Reference: Engineering Services
 553 Bumpas Creek Rd.
 Dunn, NC
 Project No.: DRB2501-0243-A

As requested by the client, a representative of Tyndall Engineering & Design, PA (TE&D) has reviewed the following item(s):

Foundation Plan
Existing New

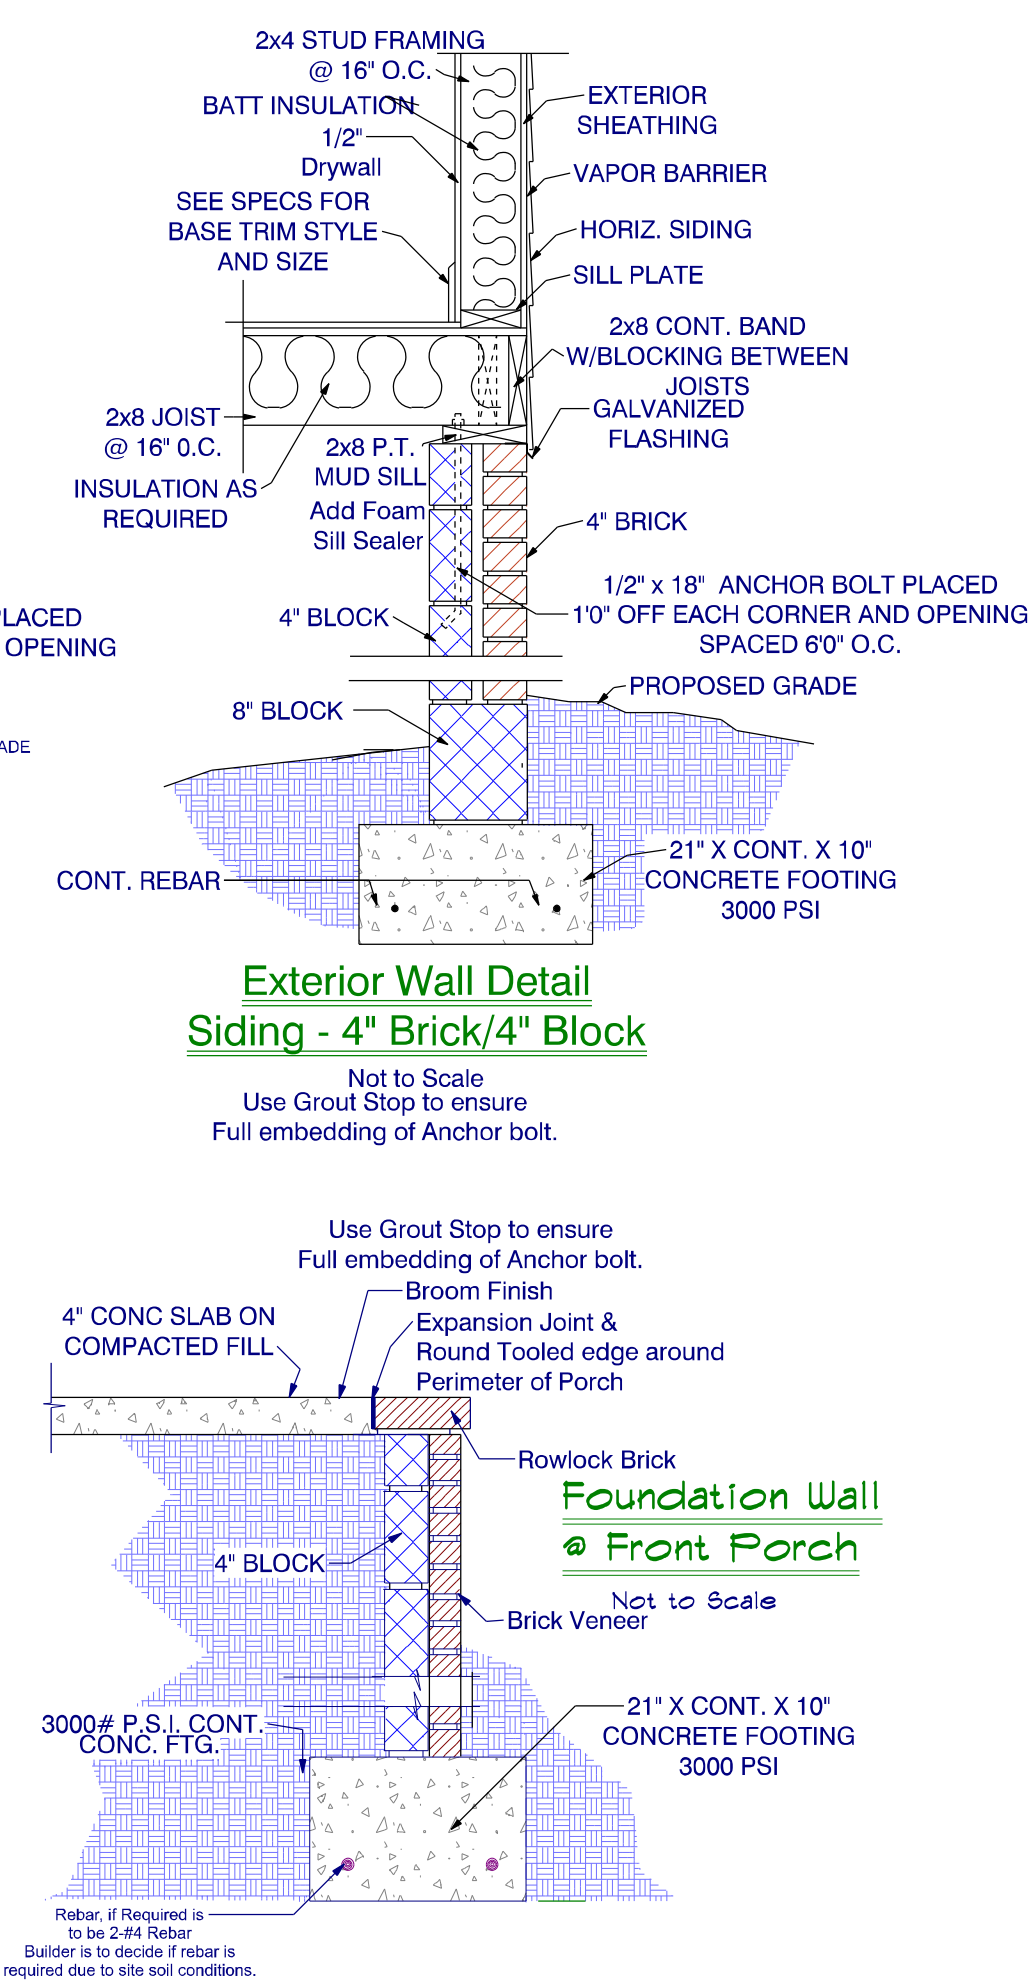
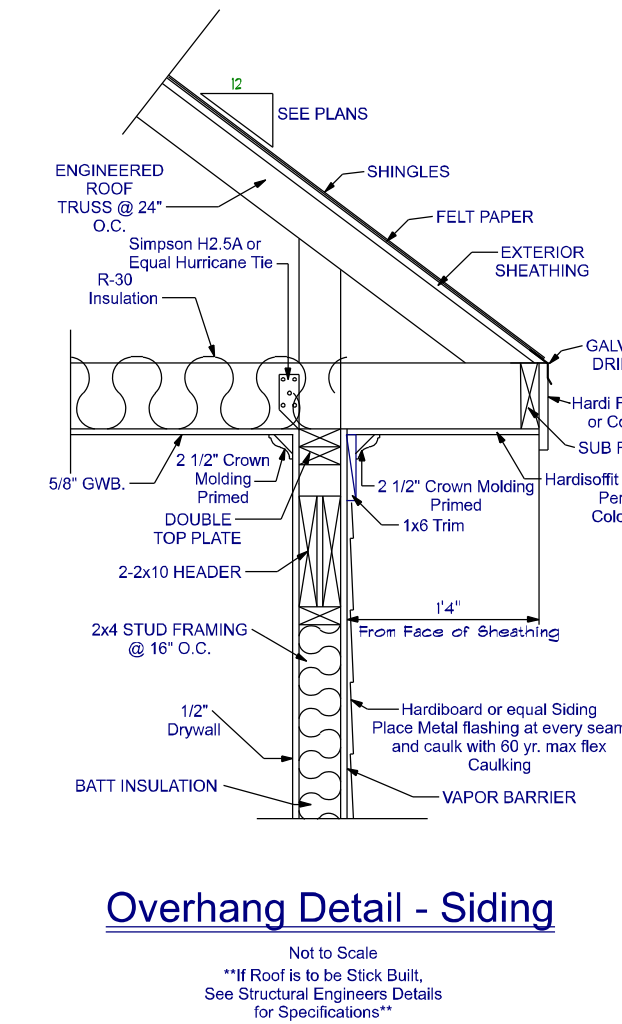
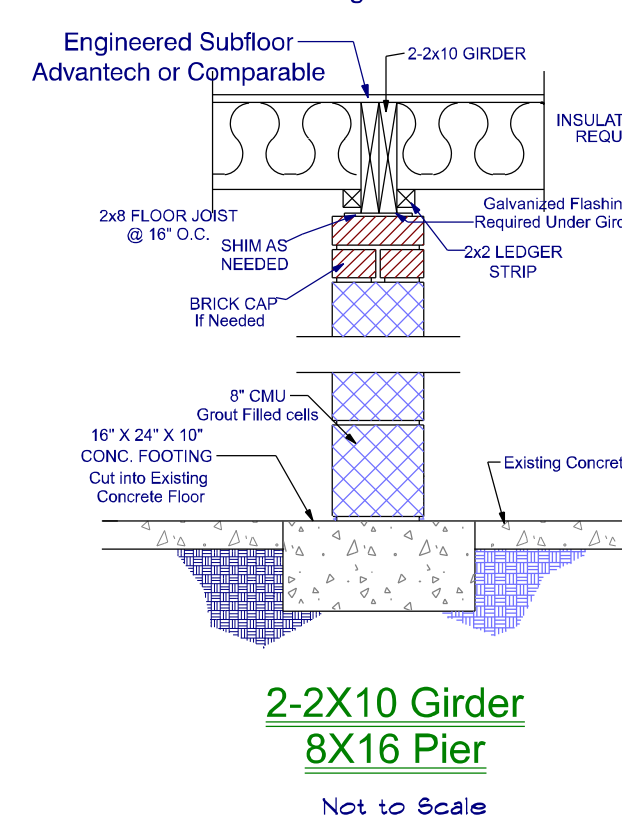
- 1) 2x8 @ 16" O.C. SYP #2 floor joists in-lieu of the plan specified 2x10 floor joists @ 16" O.C. SYP #2 at the rear addition and the finished garage areas.
- 2) (2) 2x6 @ 16" O.C. SYP #2 in-lieu of the plan specified 2x8 @ 16" O.C. SYP #2 at the sunken shower area.

- 1) Based on our plan review and analysis, the proposed 2x8 @ 16" O.C. SYP #2 floor joists in-lieu of the plan specified 2x10 floor joists @ 16" O.C. SYP #2 will adequately support the anticipated loading conditions.
- 2) Based on our plan review and analysis, the proposed (2) 2x6 @ 16" O.C. SYP #2 in-lieu of the plan specified 2x8 @ 16" O.C. SYP #2 will adequately support the anticipated loading conditions.
